# CITY OF ALBUQUERQUE

**RE: Valle Prado Unit 3  
Drainage Report for Valle Prado at the Trails Units 3  
Engineer's Stamp Date 10-24-2014 (File: C09D011A)**

UNIT 3 BASIN MAP

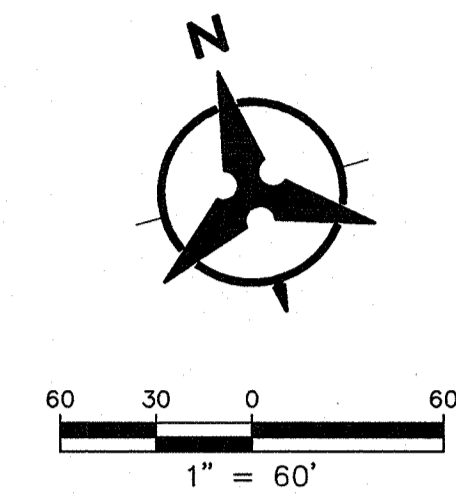
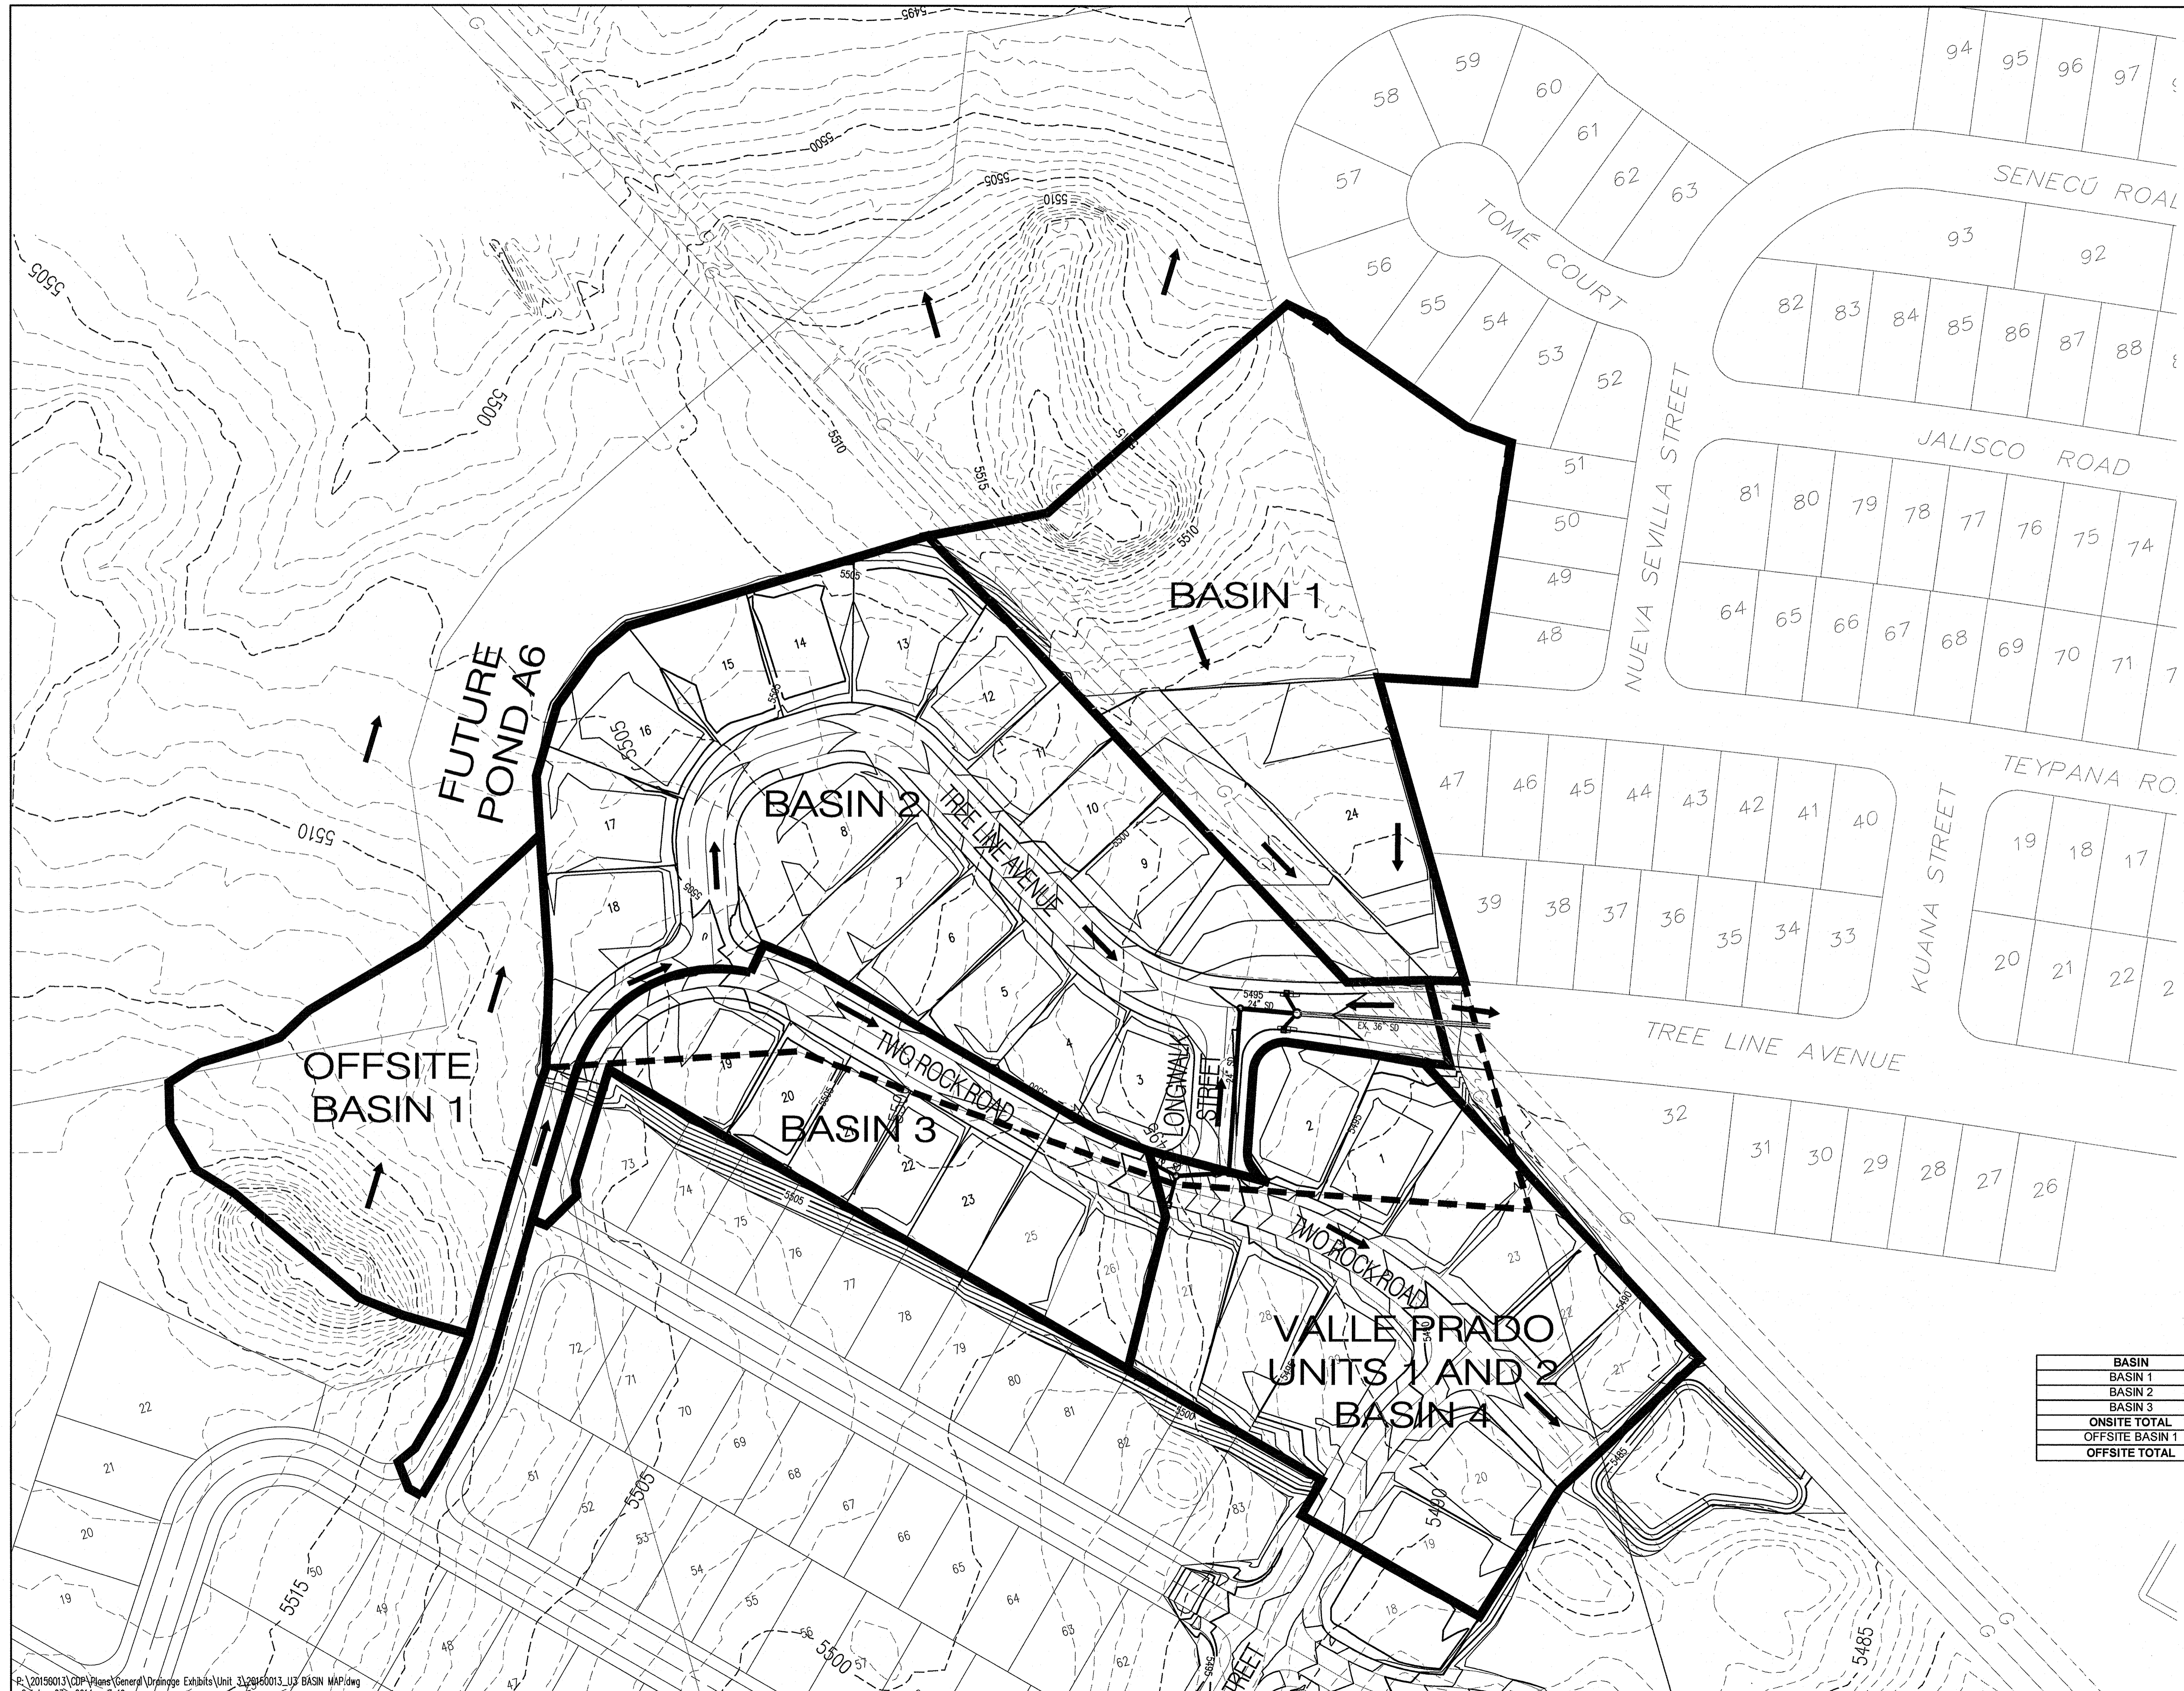
7. Drainage Report (IV) states Unit 3 is 14.5 Acres, but Basin Map shows 9.1 Acres.
8. What is the datum difference in order to compare to earlier and adjacent work orders?

GRADING PLAN

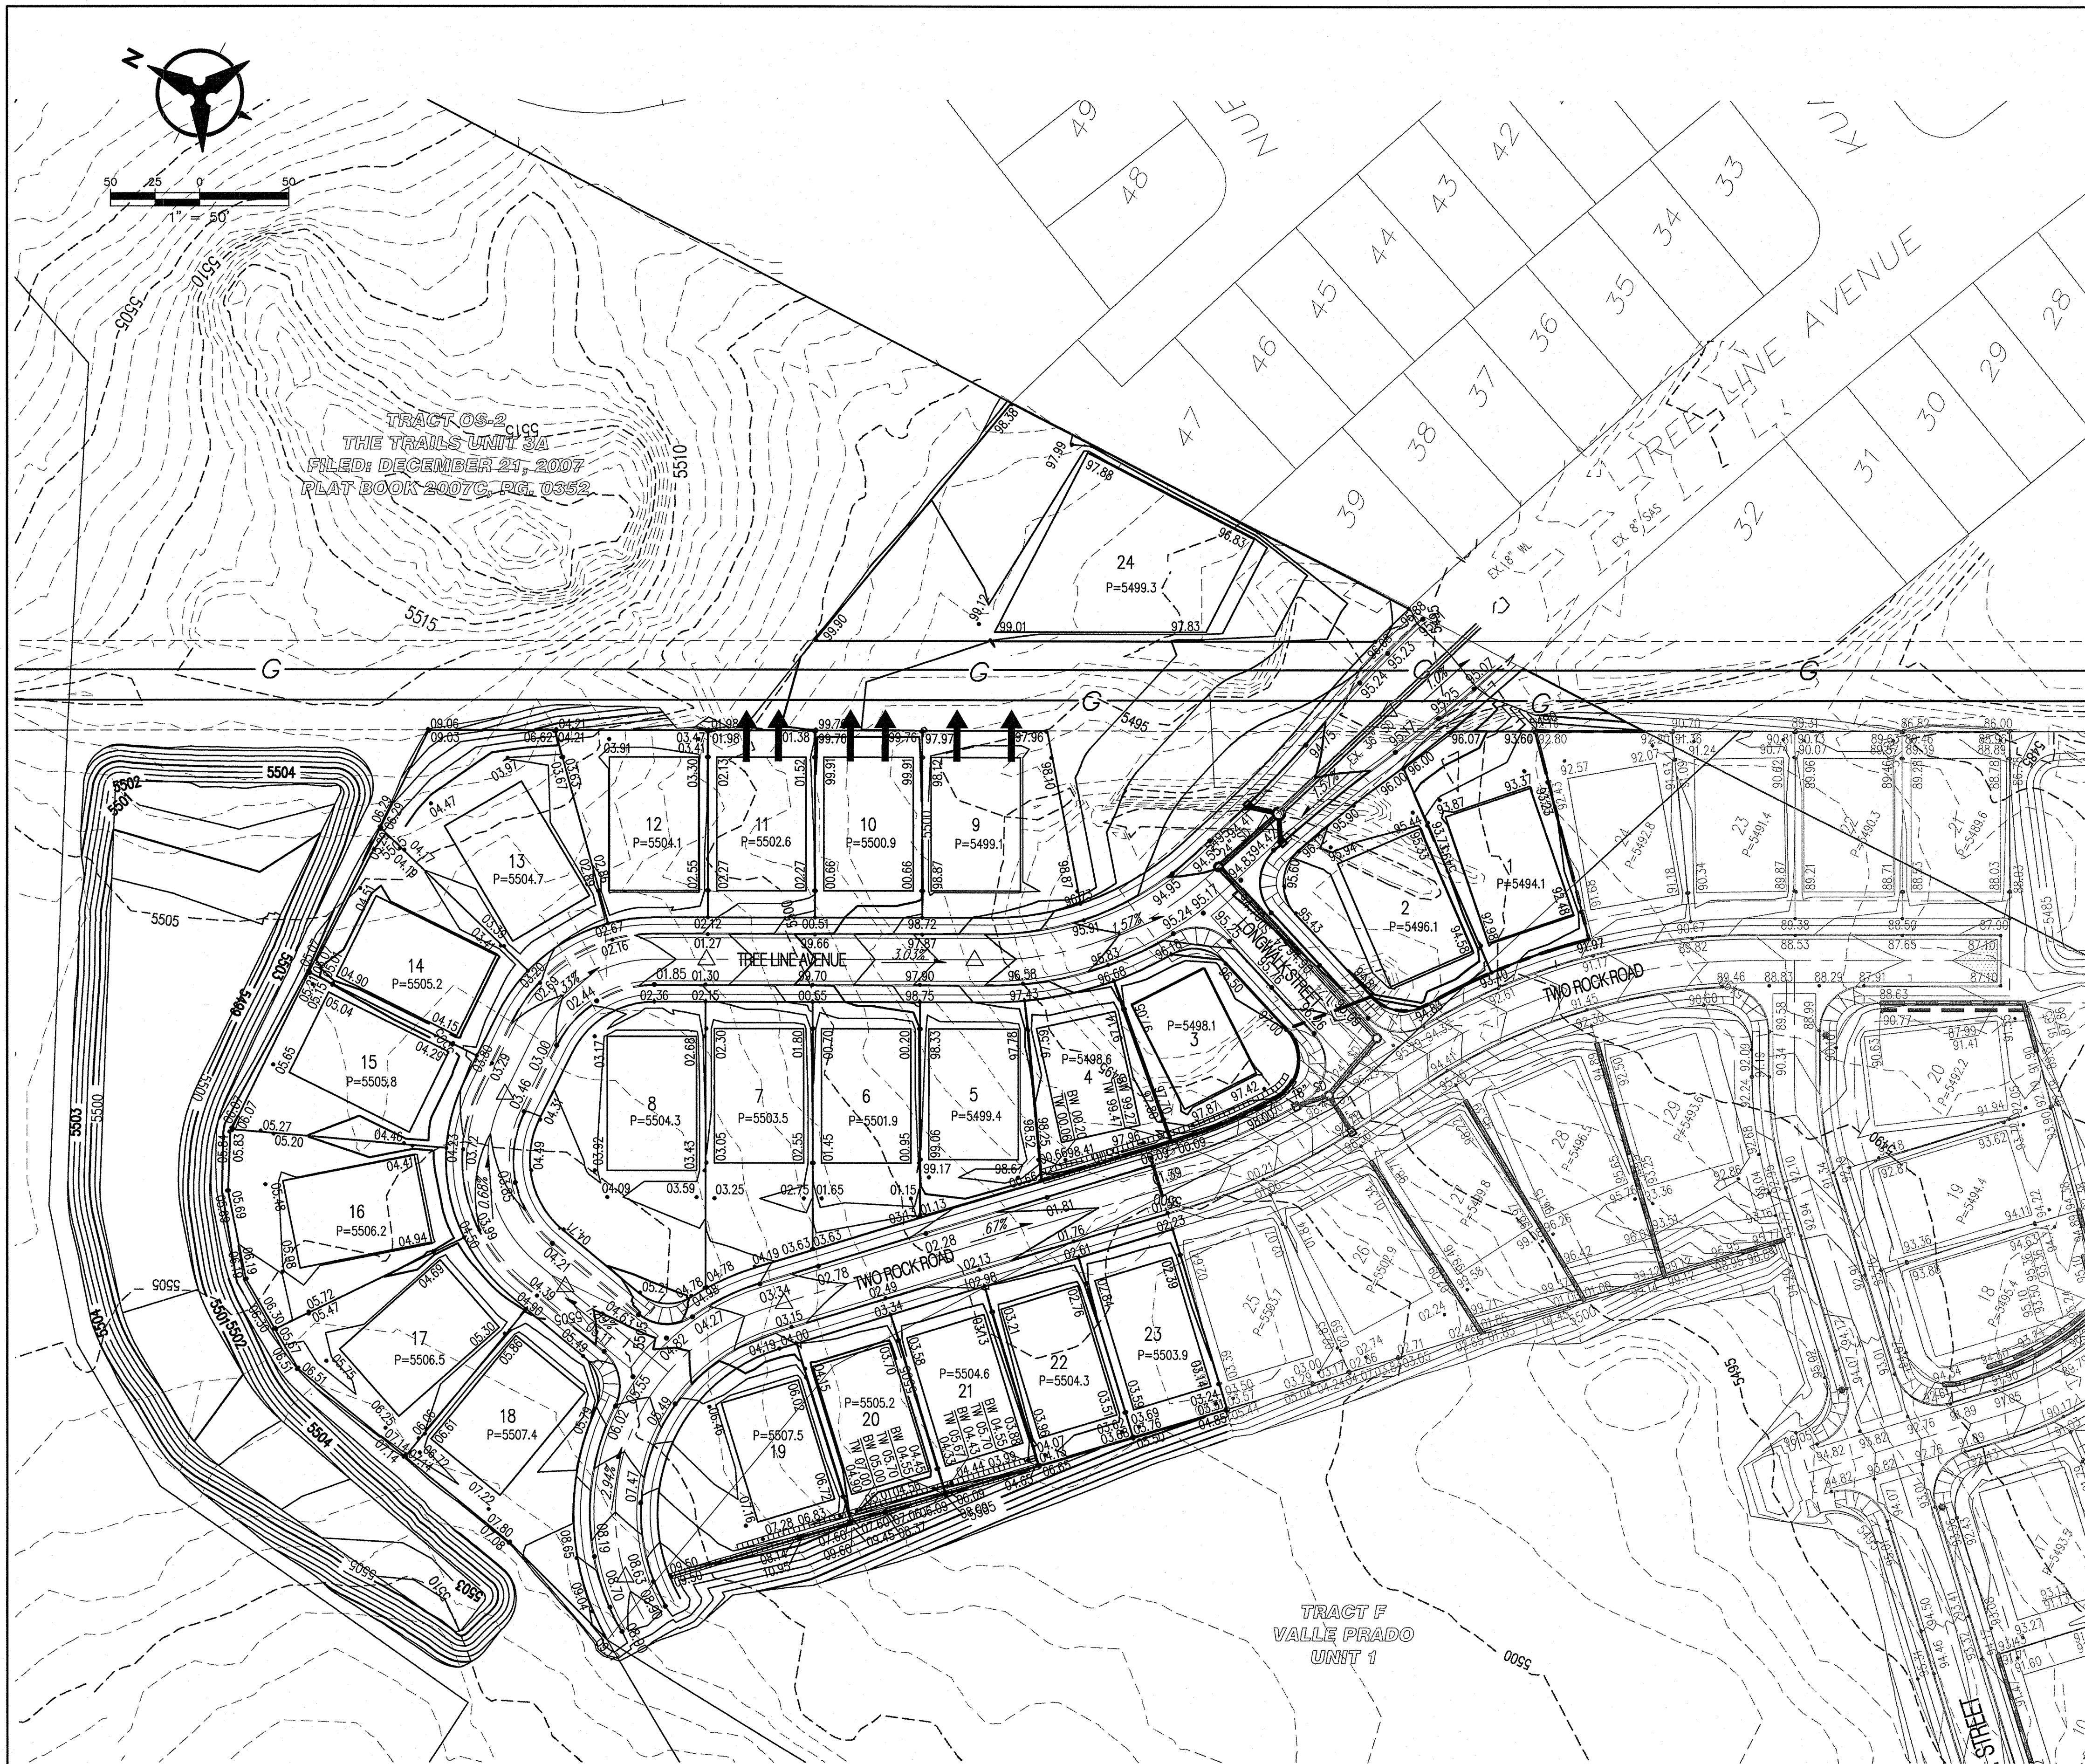
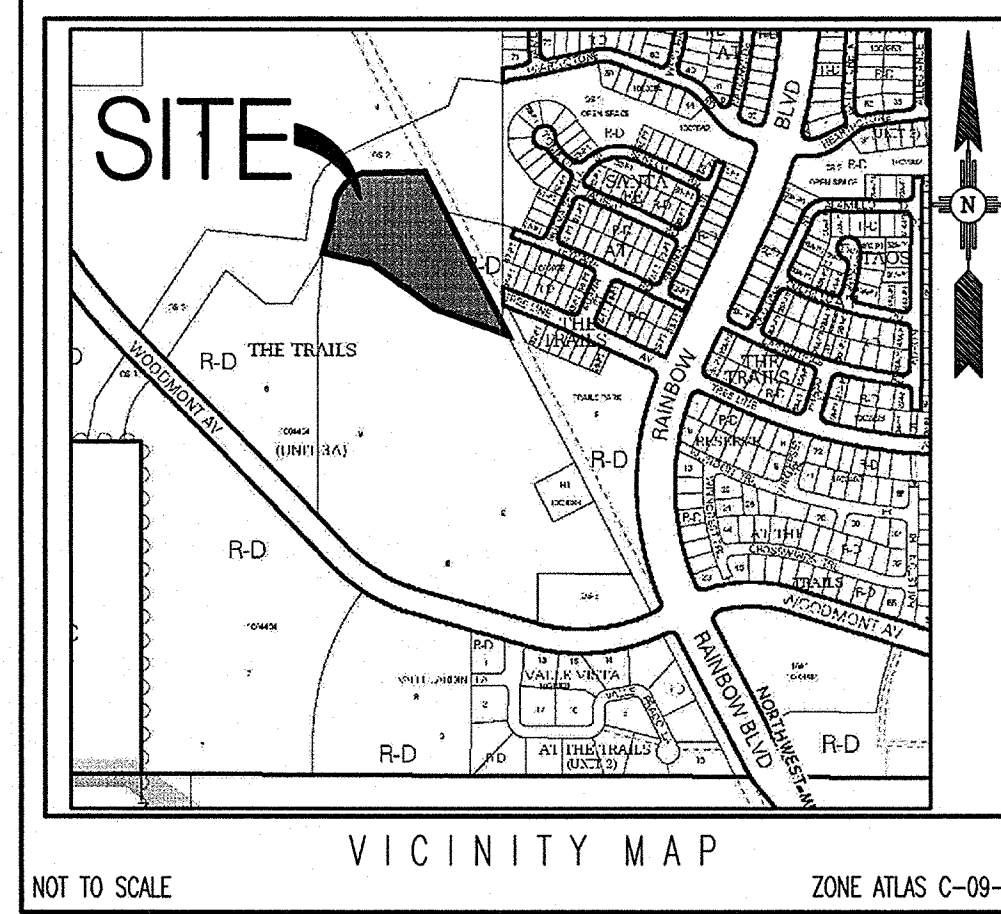
2. Tract OS-2 seems to have historically drained thru Lot 24. Wall on North side of lot needs to allow historic flows to pass. The G&D Plan shows that runoff is directed towards the east side of the lot, which may impact adjacent Lots 39 and 47. What are the pad elevations of these lots? Show grades beyond property line. Is there a wall? It would be preferable for offsite flows to drain to gas easement side.

3. Most of Lots 9, 10, and 11 drain to gas easement as opposed to Tract A or Tree Line Avenue.
4. Parks and Rec. would like a train alongside Pond A6. How does this impact the required pond volume, and subsequently this development?

5. Can a retaining wall be avoided on lots 3 & 4?
6. Why is the grade raised to 5510' South of Lots 19, 20, and 21? How does this fit in with the future plans for the extension of Two Rock Road to the future Sandmark Road and the Future Basin 3 (from Unit 1&2 Drainage Report)?

9. Show existing flowline elevations and slopes where Treeline ties into the existing at Santa Fe at the Trails.
